From: Sue Howell <Sue.Howell@arun.gov.uk>
Sent: 13 February 2020 14:54
To: Planning.Responses <Planning.Responses@arun.gov.uk>
Cc: David Spring <David.Spring@arun.gov.uk>
Subject: FW: Planning Consultation on: BE/126/19/PL

Application ref: BE/126/19/PL

Description: Erection of a 1410 square metres discount convenience retail food store (Use Class A1) and parking, landscaping and other associated works.

Location: Land at Phase 1A Oldlands Farm, Shripney Road, Bognor Regis PO22 9NN

AD 110_REV C

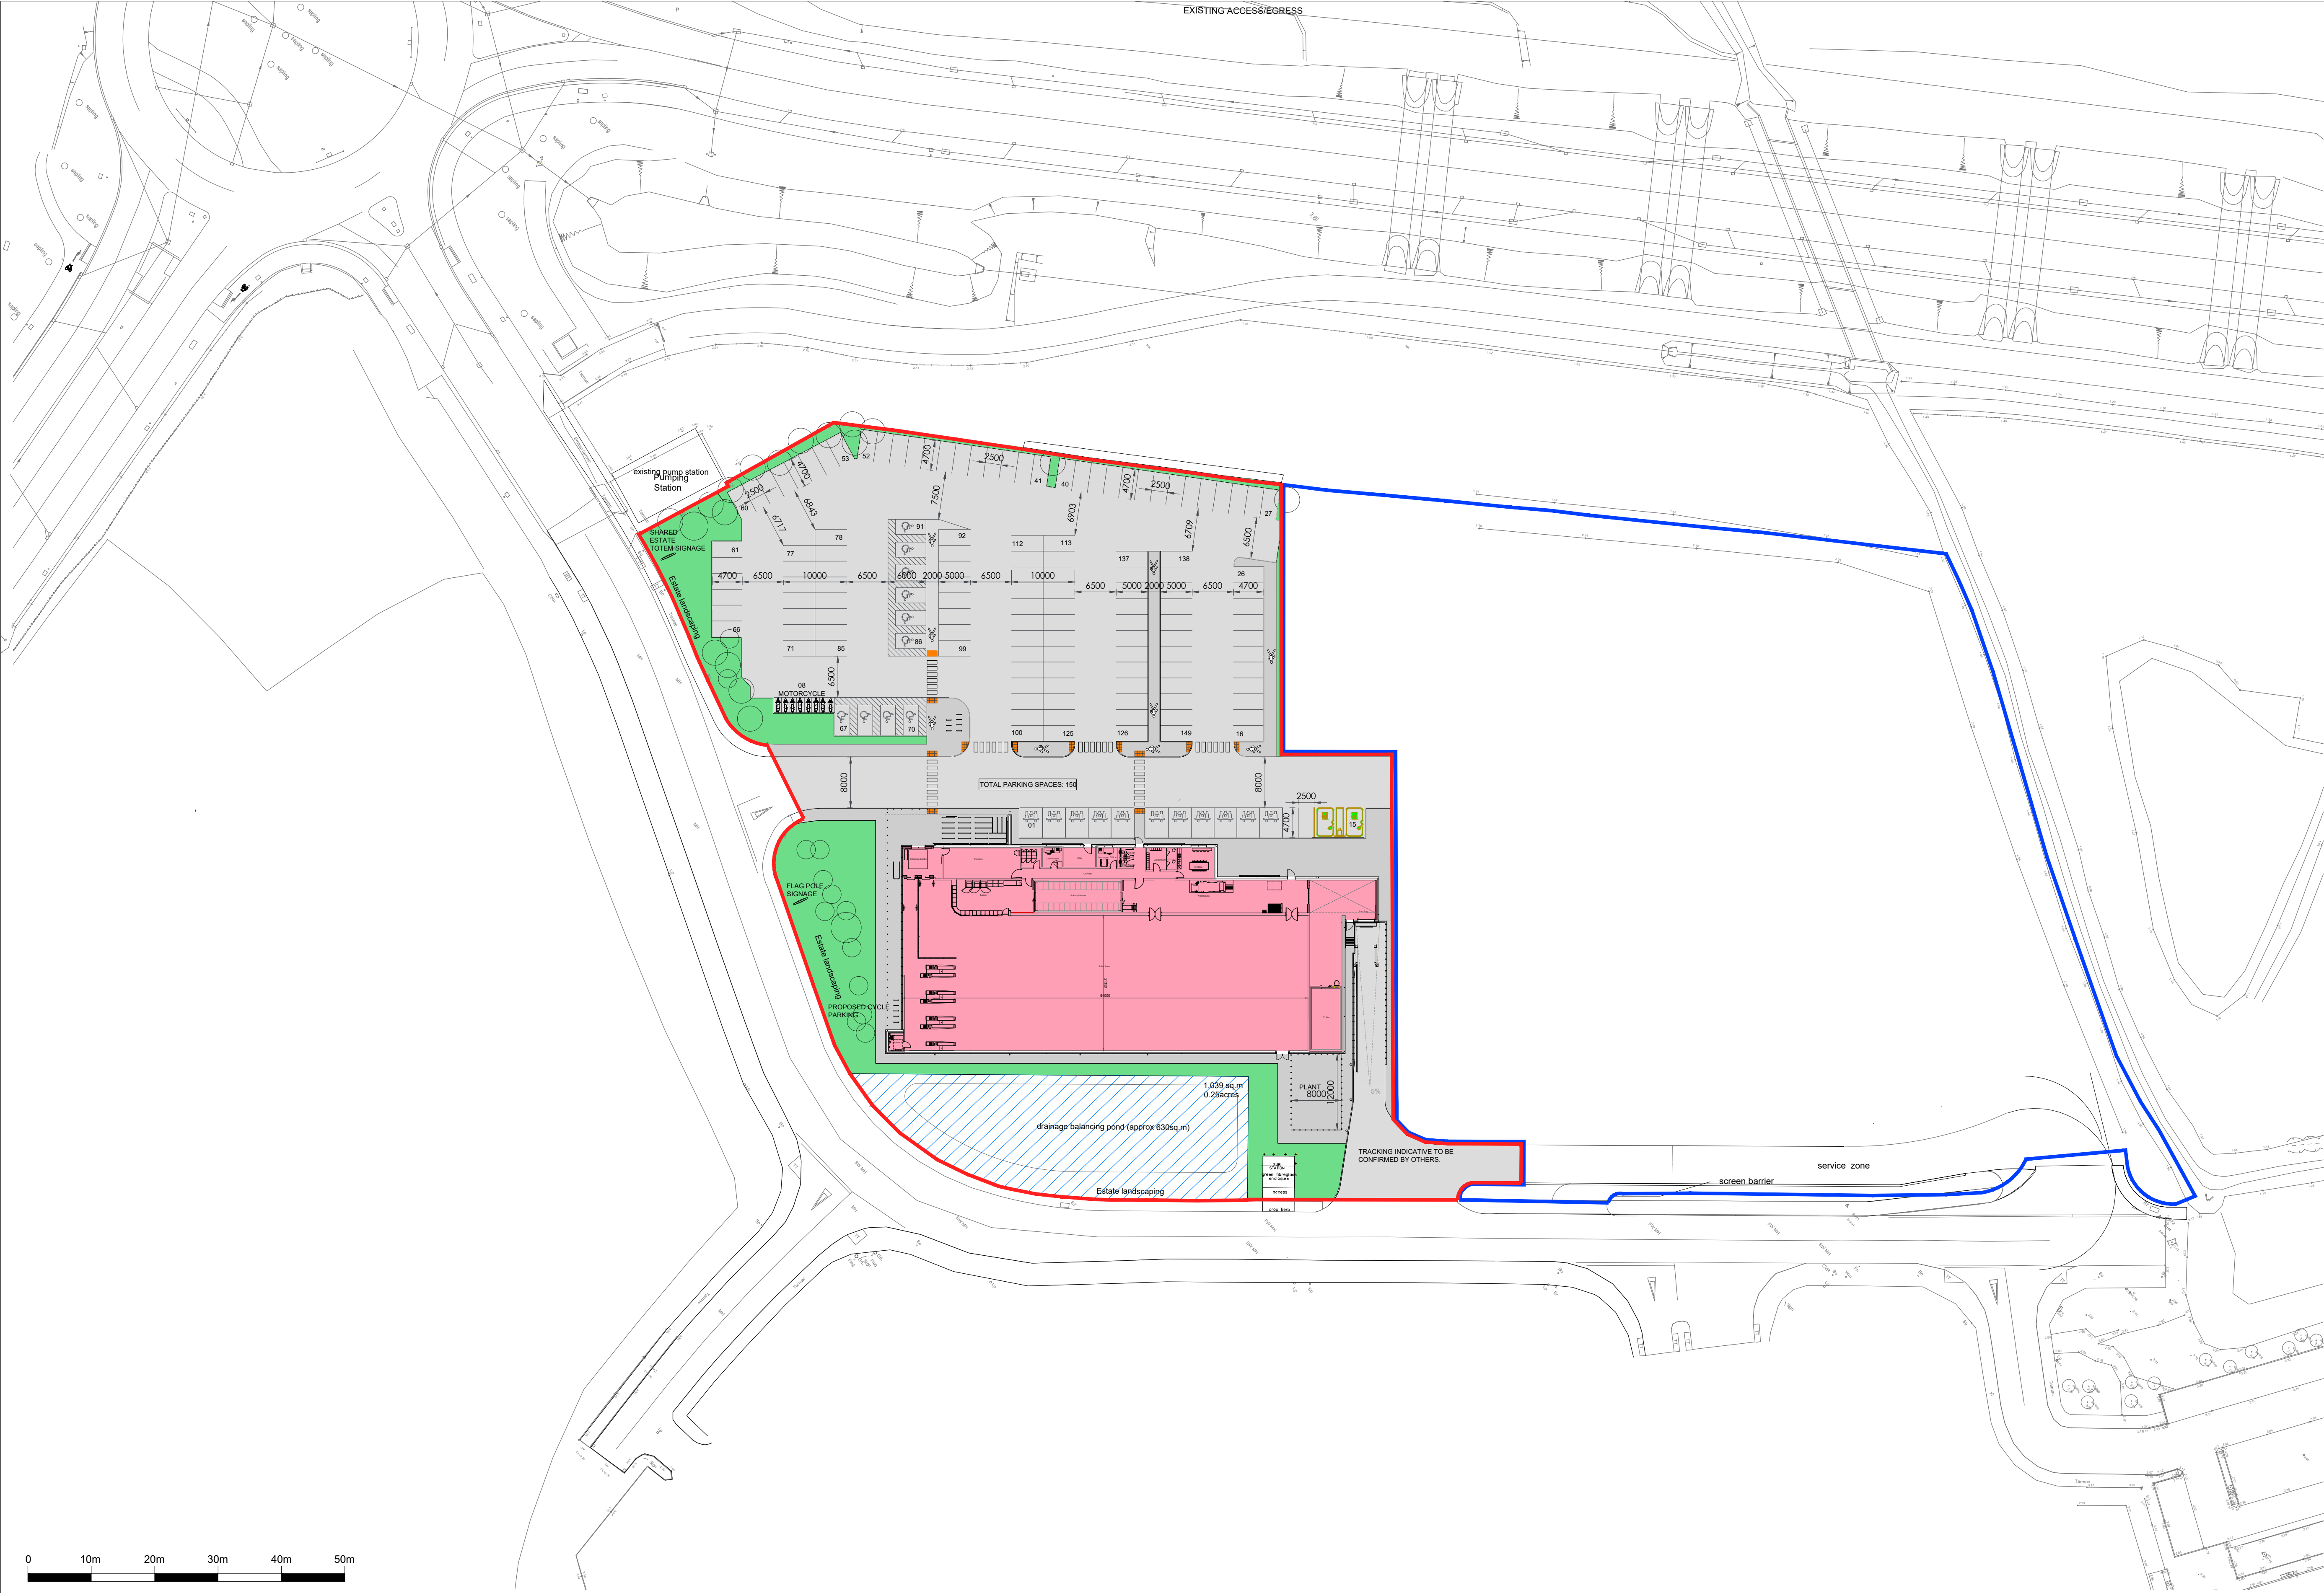
The revised scheme does not deliver a suitable improvement, with the addition of 5 no stand-alone trees within the bland expanse of hard car park surfacing and poor boundary treatment which lacks imagination and species choice diversity.

Further landscape provision to the main area of carparking with the incorporation of planted areas for trees and shrubs. The green boundary treatment along the boundary edges to be increased in size to cater for a suitable planting scheme, given sufficient space and growing medium to be able to establish and thrive. The boundary treatment areas to incorporate tree species in the design. Trees specified should be at a size which allows instant impact, but which will establish and mature as the site develops.

I would have to recommend that **the landscape proposals in dwg AD 116 Rev A are still inadequate**. I would recommend further revision required to address my concerns raised to expand and improve on the scheme presently submitted in relation to the main carpark area where trees and shrub beds need to be added and for the inclusion of tree species and improved shrub species choice along the boundary edge.

The NPPF para 124/127 relate to good design principles which equally apply to commercial development. The Landscape proposals in One Design Dwg AD 116 Nov 2019 Proposed Landscape Design and Specification have proposed a scheme with suitable shrub species for location and purpose, but which are limited to largely the periphery of the development proposals. There are very few trees proposed within the scheme but particularly lacking from the large car park area where they should be incorporated to break up the large featureless car park. The hard expanse of carparking to the frontage of the proposed store as presently shown is bleak and lacking in good design and would offer little for biodiversity provision.

Further landscape provision to the main area of carparking with the incorporation of planted areas for trees and shrubs. The green boundary treatment along the northern boundary to include tree species. All areas should be considered and their connection for biodiversity and habitat explored. Trees specified should be at a size which allows instant impact, but which will establish and mature as the site develops.
